Application No: R/122/22/HH
Site Address: Berrow Milton Avenue Rustington BN16 2PP
Description of works: Single storey side and rear extension and hip to gable loft conversion including the installation of 1 x rear dormer following the demolition of existing garage.

Thank you for your internet representation made on 6th July 2022 which has been recorded as an objection with the comments as follows:

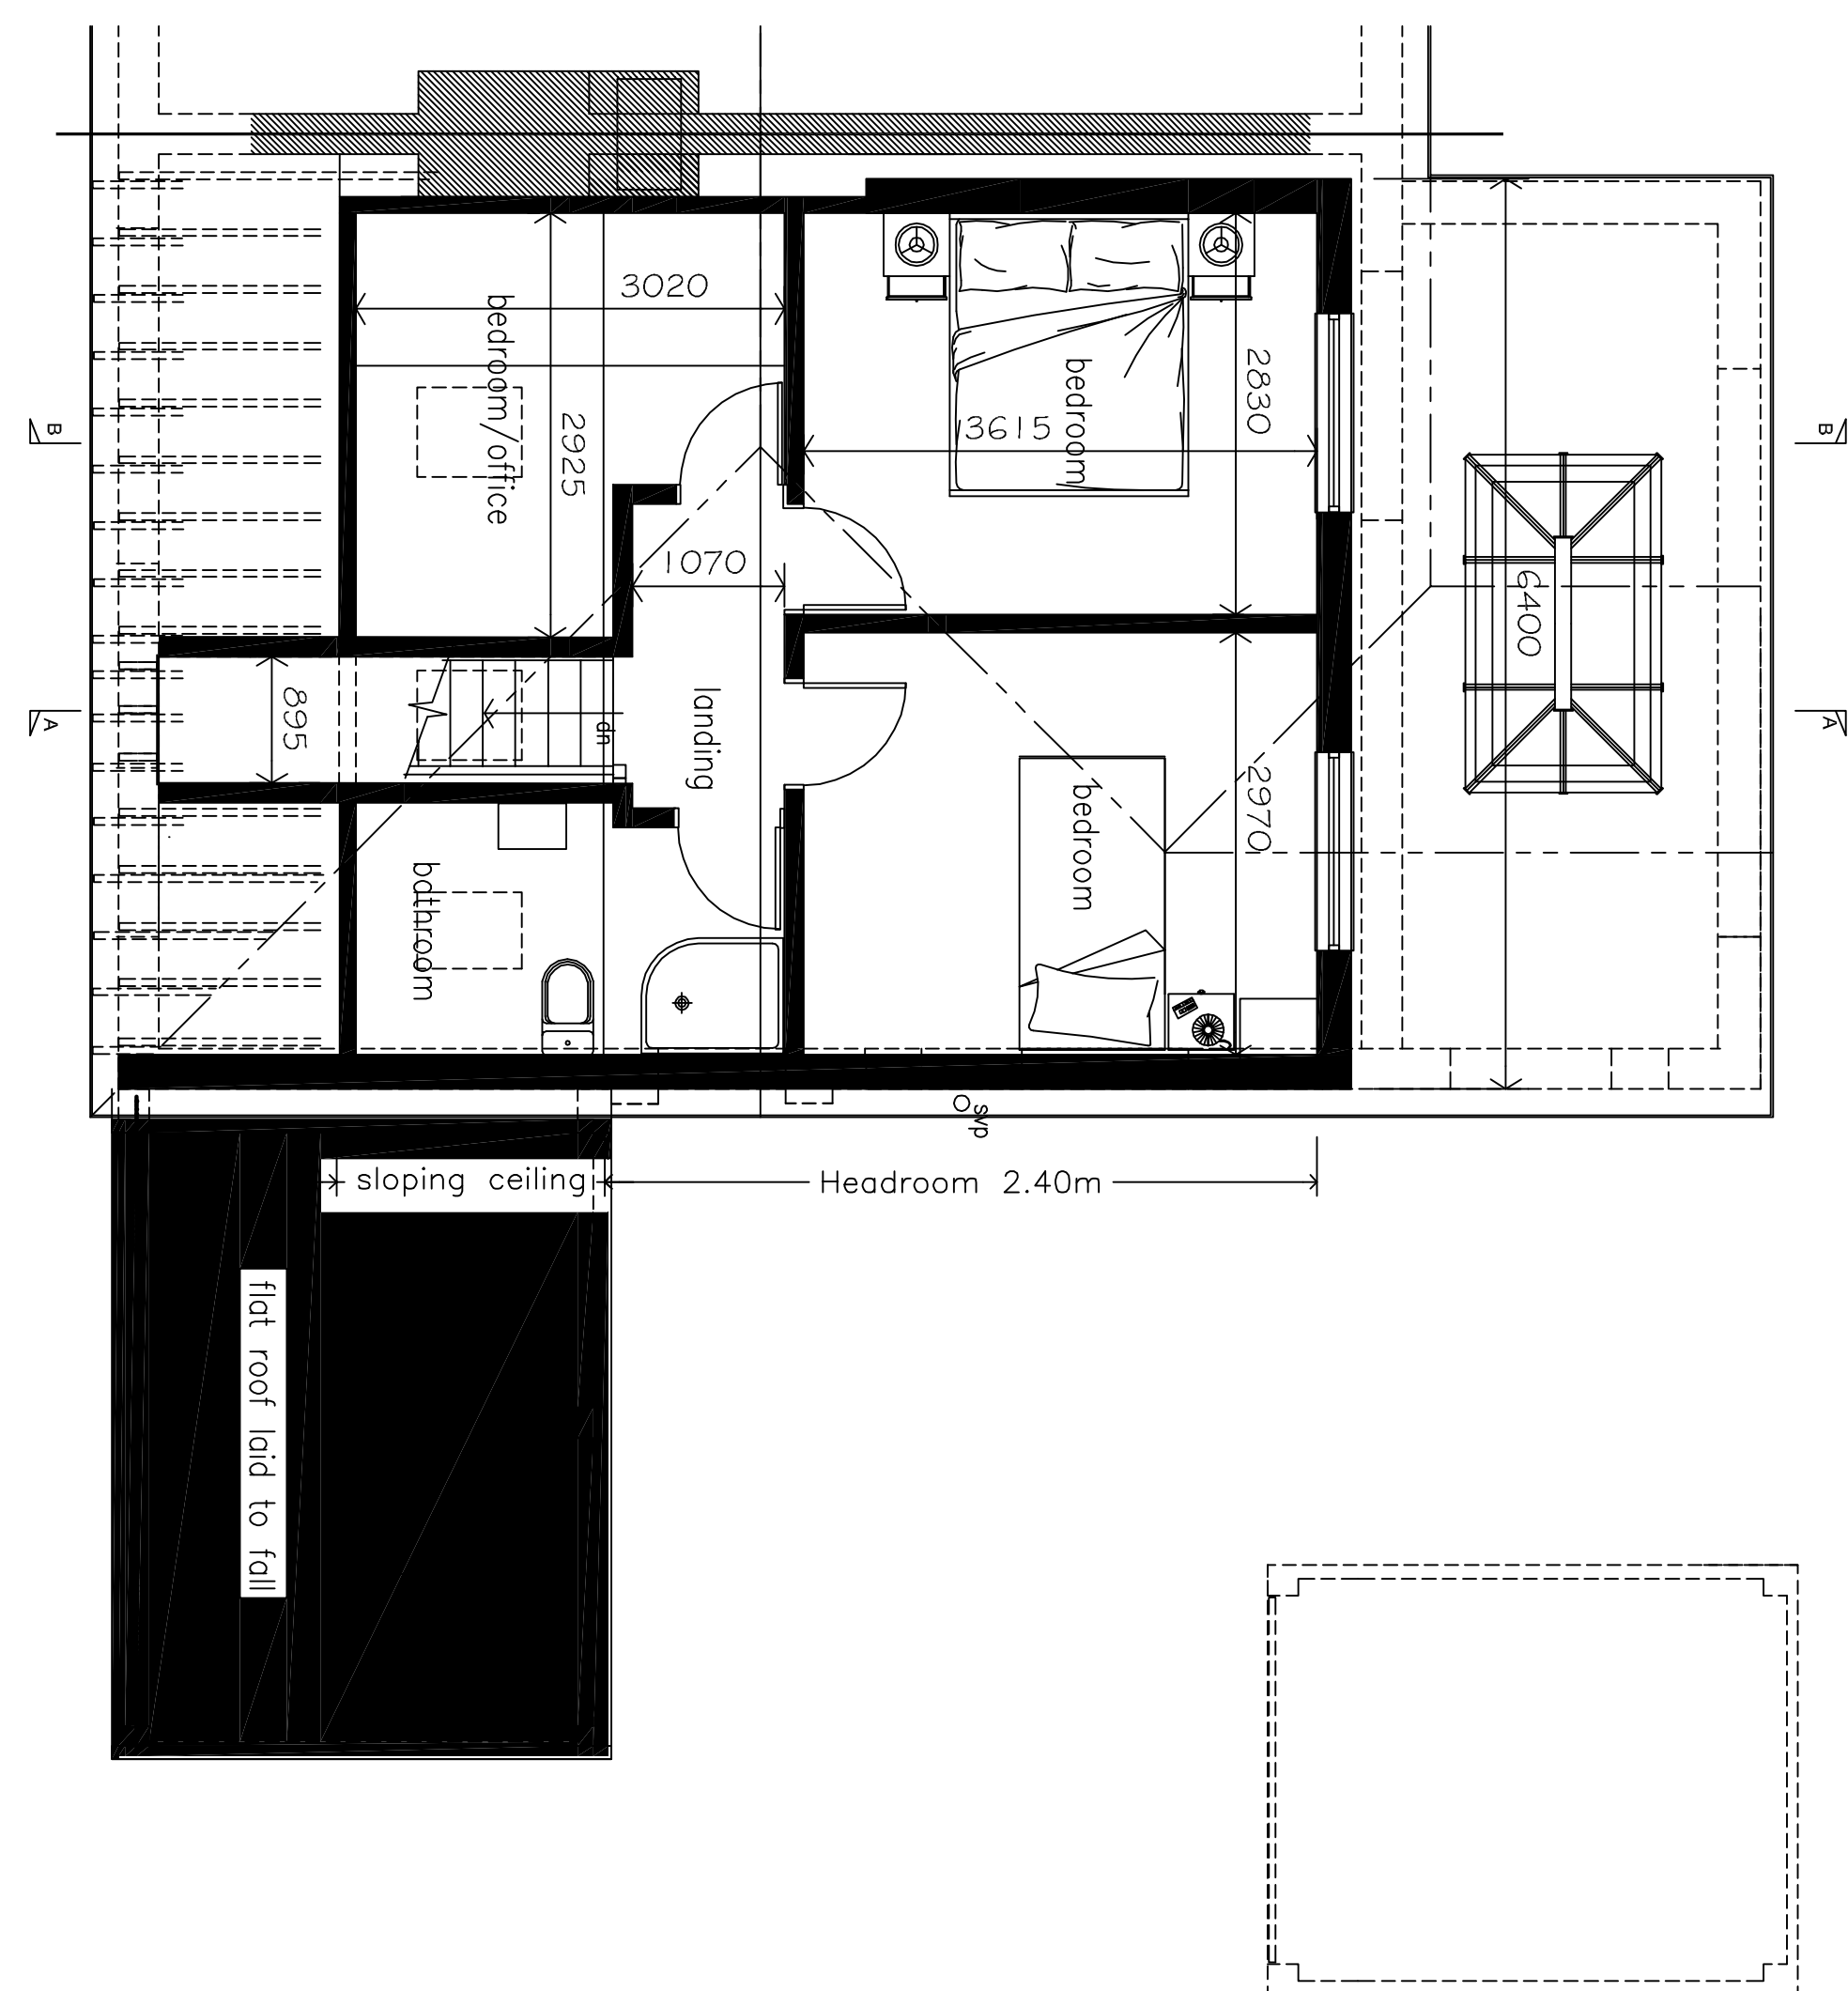
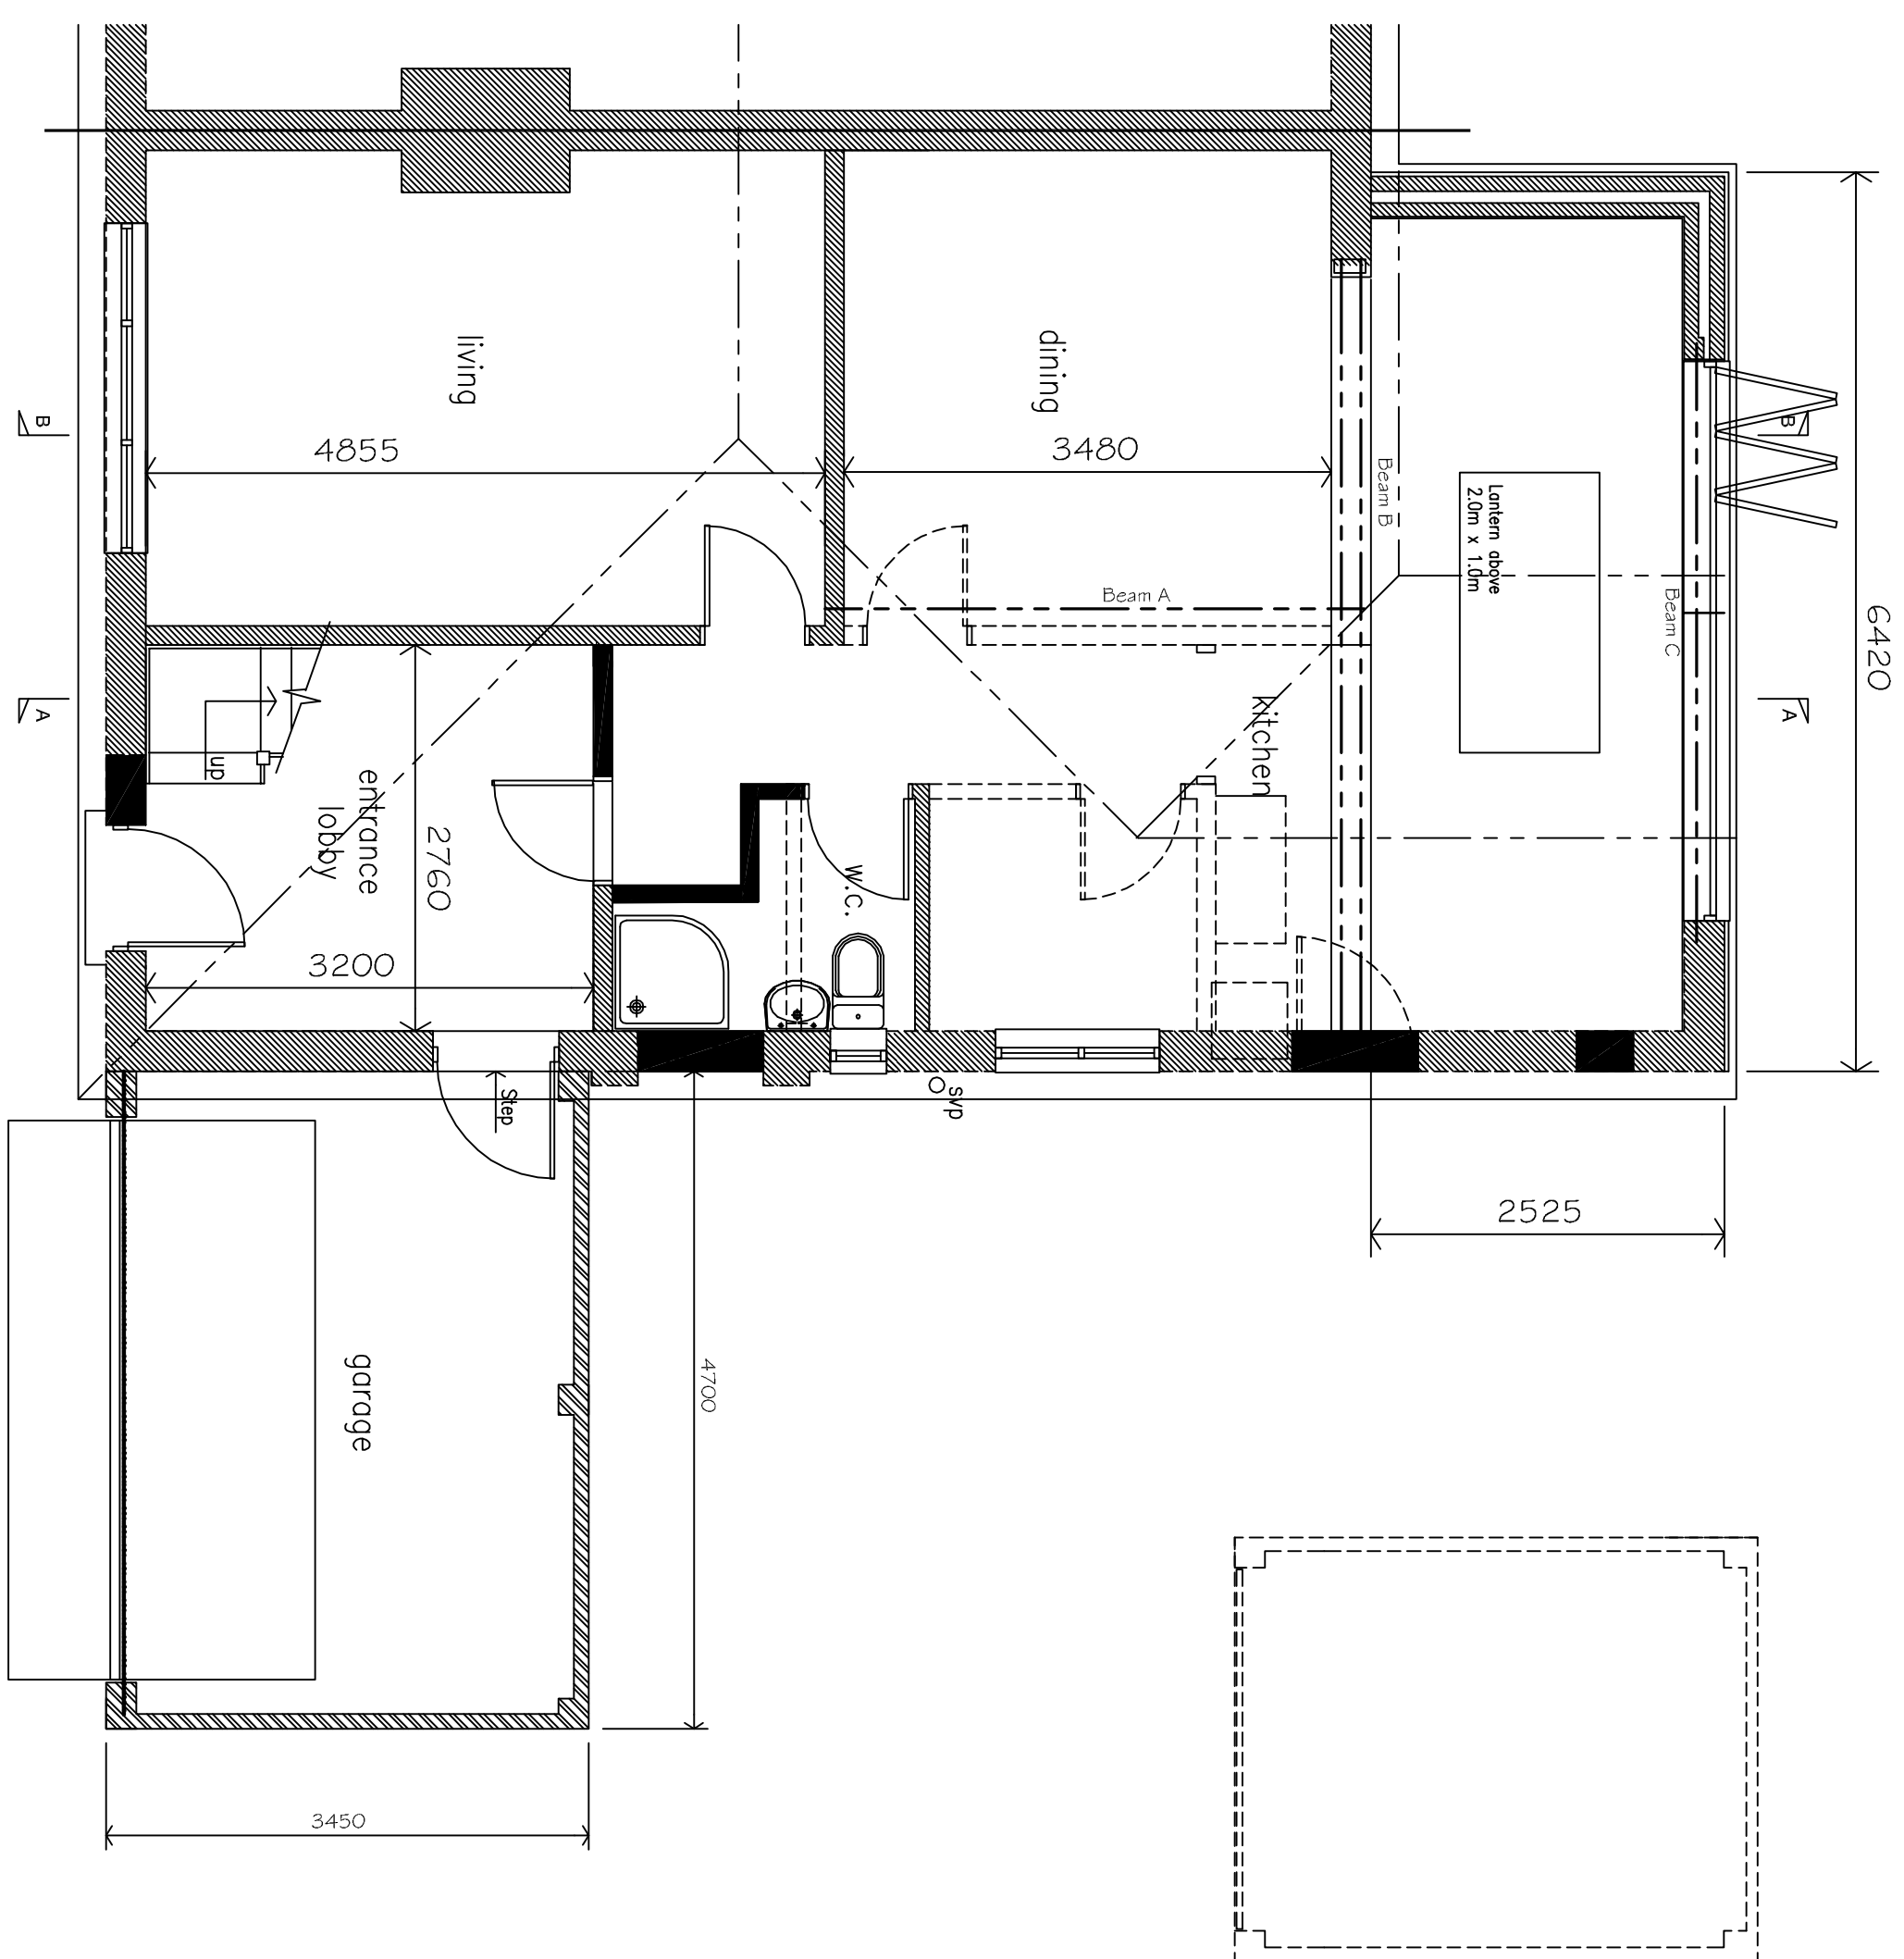
The single storey rear extension and loft conversion will severely effect Linsals privacy and access to natural sunlight. The existing patio area in Linsals garden will be in the shade.

There is a path way (one metre wide) which runs along the rear garden of Berrow to allow access into Linsals garden. This path must be kept clear at all times to allow access. Previous residents of linsal would daily take their bicycles to and from the garden. The new proposed rear extension would loose any privacy as the structure would be approx. 4 metres from the path way at its widest point.
